M54 to M6 Link Road

Draft Statement of Common Ground with Cadent Gas Limited

HE514465-BAM-DCO-M54_ZZ_ZZ_Z-RP-DC-0009

November 2020

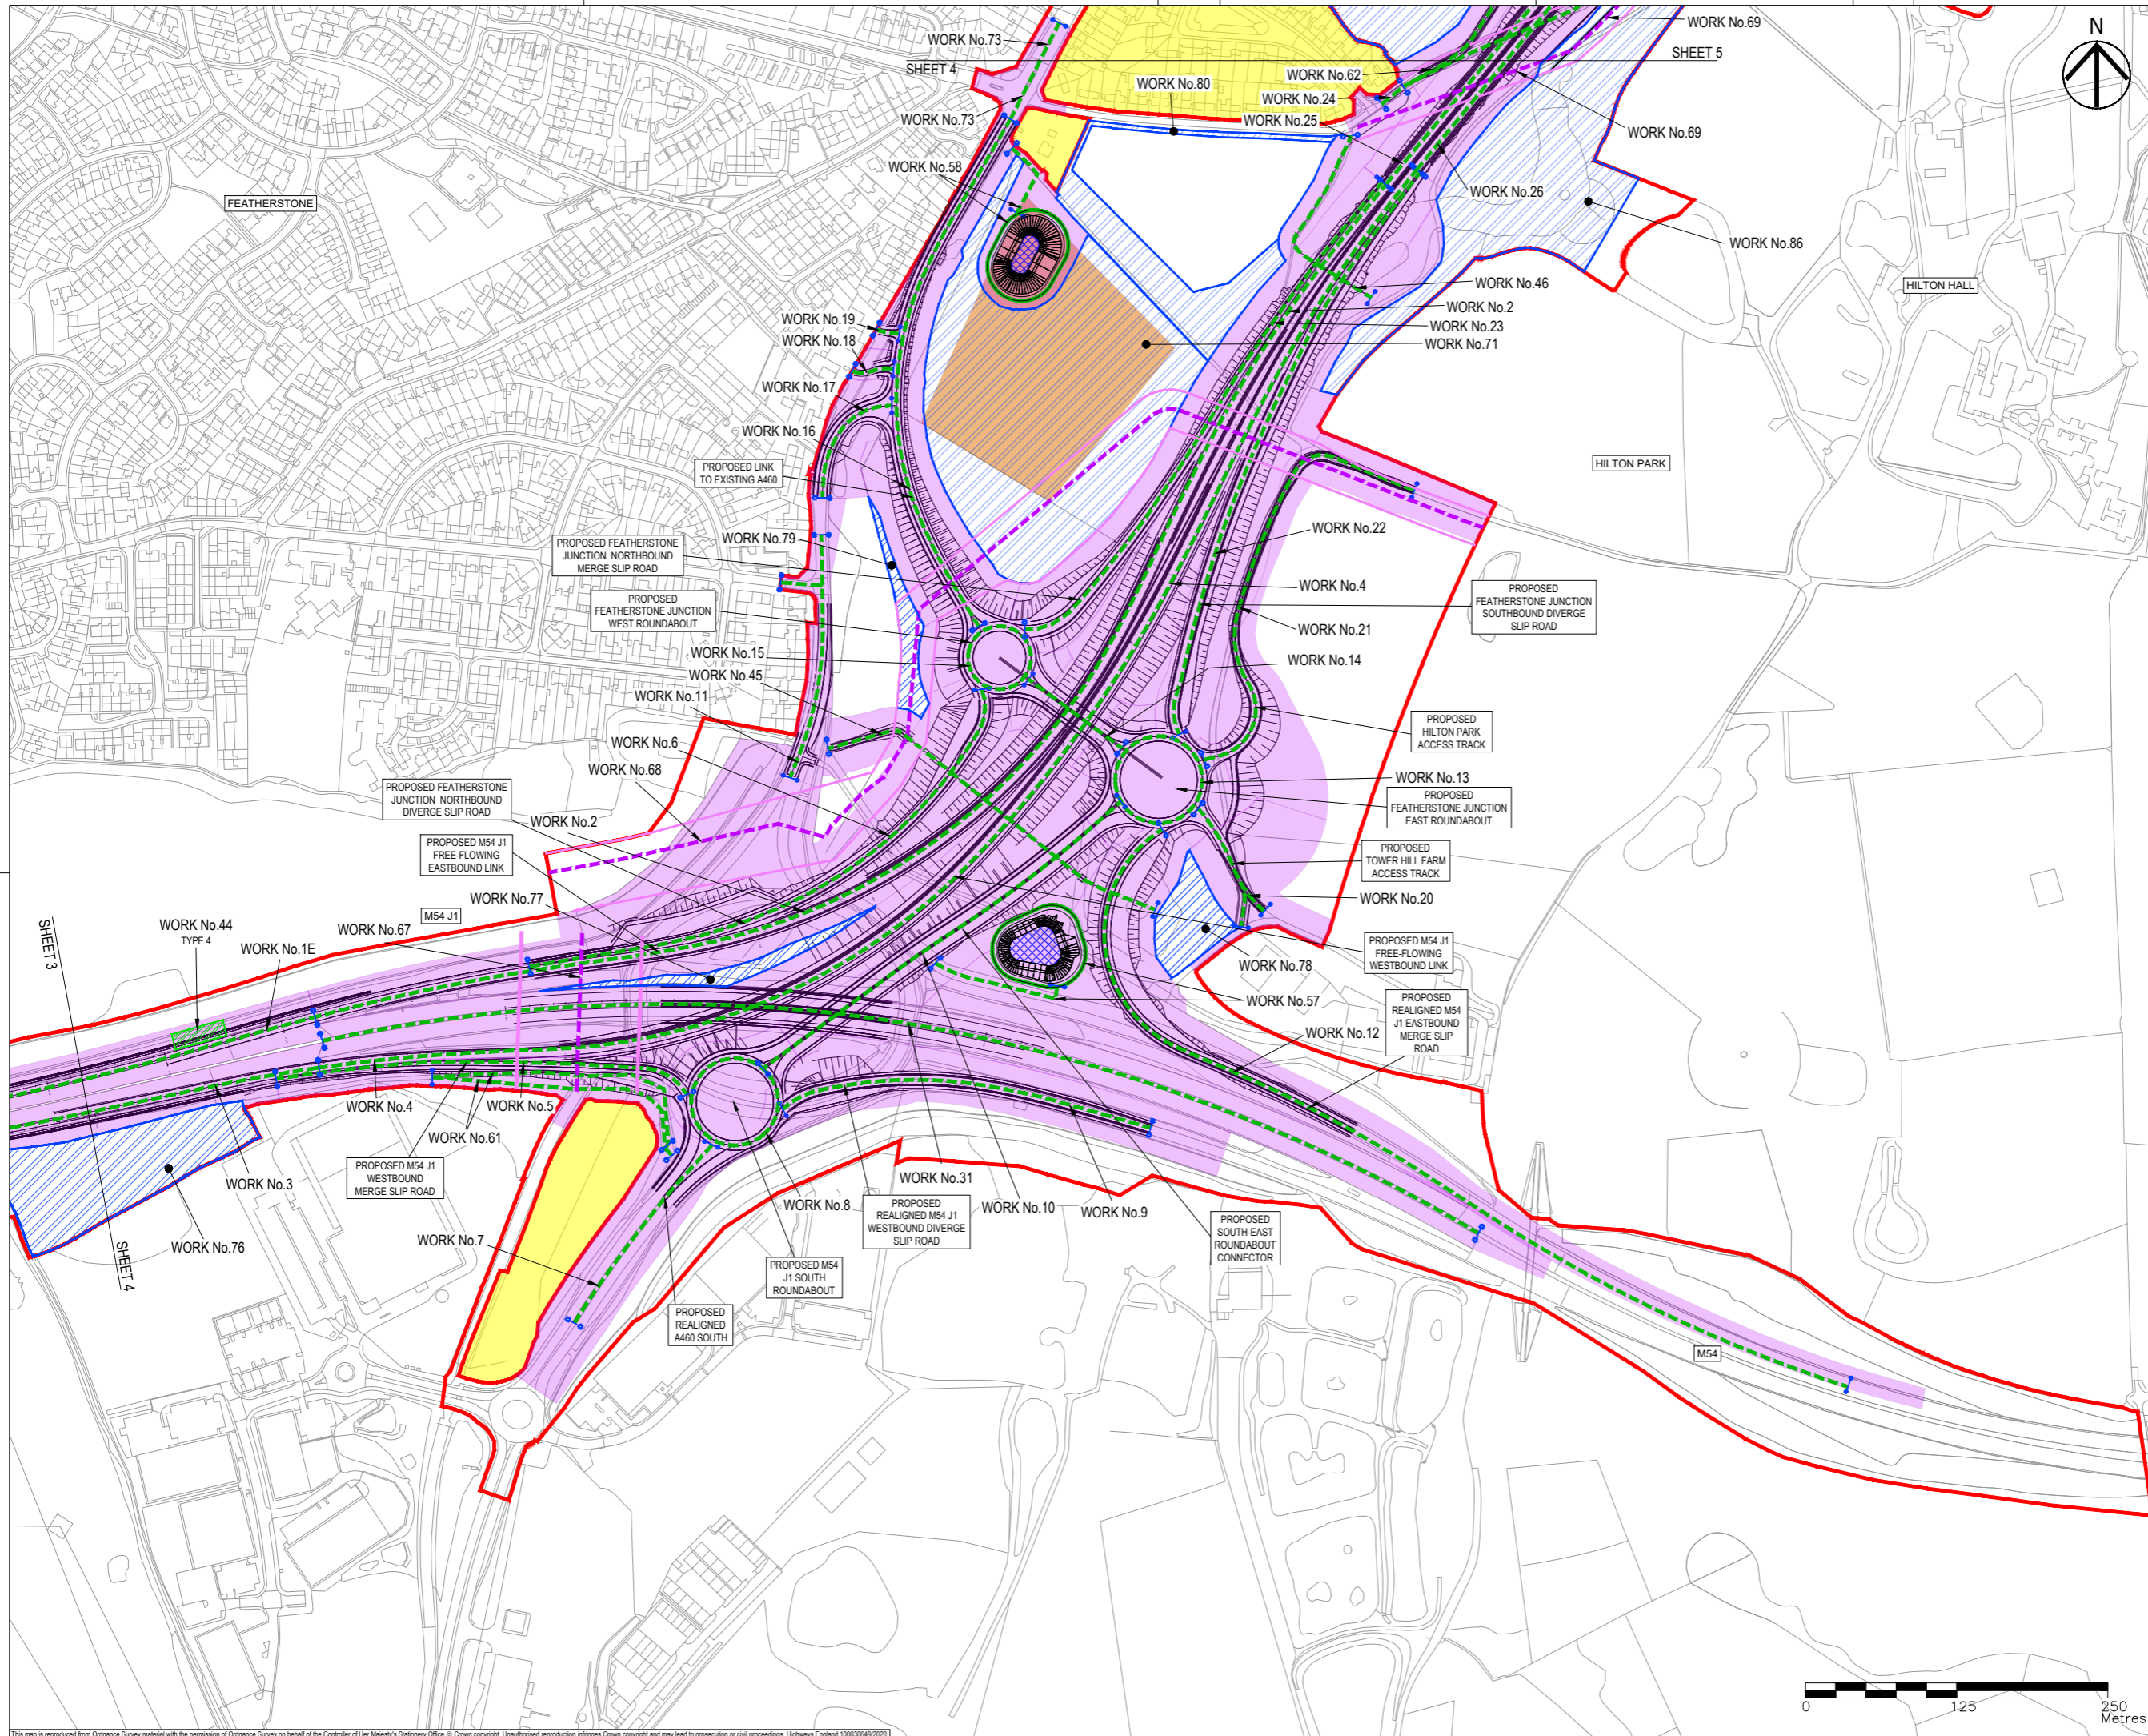
Diversion of High-Pressure Pipeline – Environmental Considerations (RR-010b)	Cadent's high pressure gas pipeline is affected in two sections by the proposed road scheme. The first section is covered by sheet 3 of the works plans and the pipeline would predominantly	Highways England will continue to work collaboratively with Cadent to ensure that any proposed planting does not create long term maintenance or access	Under discussion	High

Issue	Comment	Highways England Response	Status	Agreement likely? (app) ¹	Agreement likely? (IP)
	be within work no. 75 (hedgerow and species rich grassland). Hedgerow planting over or in close proximity to the high-pressure pipeline would need to be carefully designed and agreed with Cadent to ensure it didn't restrict access to maintain the pipeline. The second section is shown by sheet 4 of the works plans and the proposed diversion of the high-pressure pipeline is indicated by work no. 68. A section of the proposed diversion runs through work no. 79 (woodland planting). It would not be acceptable to plant trees over the diverted high-pressure pipeline as it would remove access and the roots could damage the pipeline.	issues. Version 2 of the Environmental Masterplan [AS-086 to 092/6.2] submitted to the ExA on 9 October has been updated to address the concerns raised in relation to woodland and hedgerow planting over and in close proximity to the gas main diversion route. No dense tree planting is proposed within 10m of the utilities diversion in line with Cadent's guidance note on Tree planting restrictions near gas pipes.
